PLANNING CONSULTATION RESPONSE

Application No	2025/0982
Proposal	Erection of steel frame agricultural feed and vehicle store
Address	Byre Cottage, 7 Midhope Court Mortimer Road, Midhopestones, Sheffield, S36 4GW
Date of Consultation Reply	25/11/2025
Consultee	Katie Lawrence, Planning Ecologist

Proposed Elevations

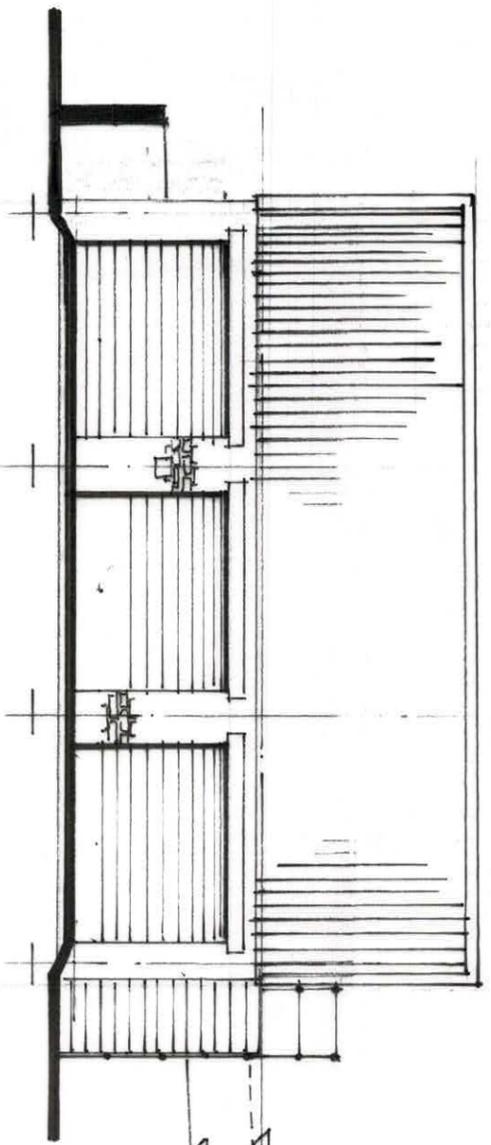
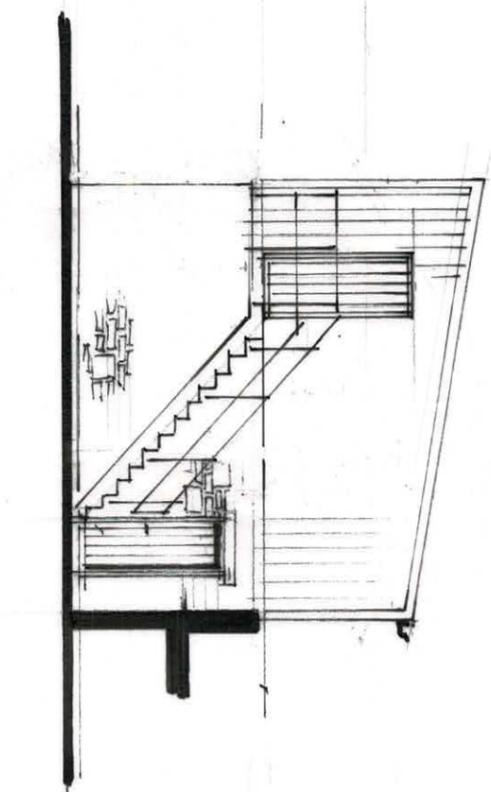
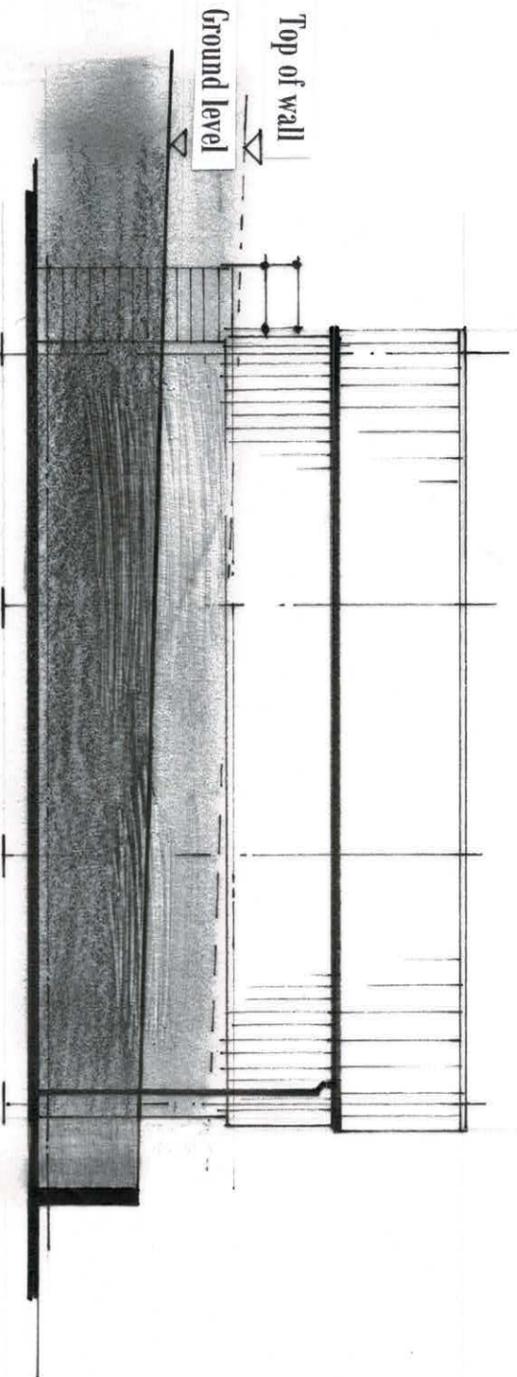
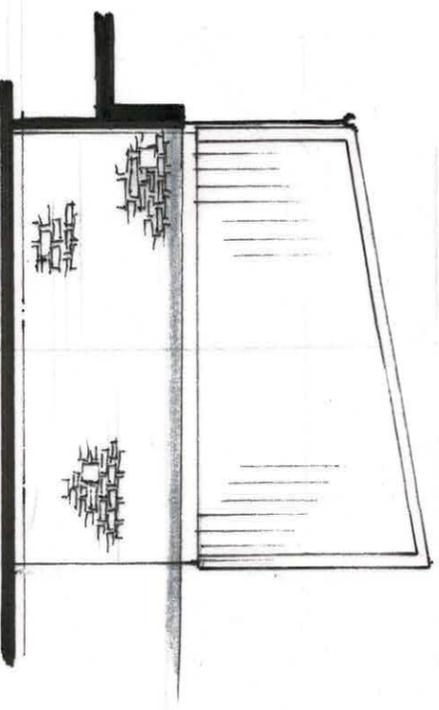
My pre-app response also advised that the proposed building should incorporate bat and bird boxes as per the Biodiversity and Geodiversity SPD and the NPPF. The applicant could provide a plan showing the type of boxes proposed and their proposed location at the application stage or this could be secured by way of a planning condition, if permission is to be granted.
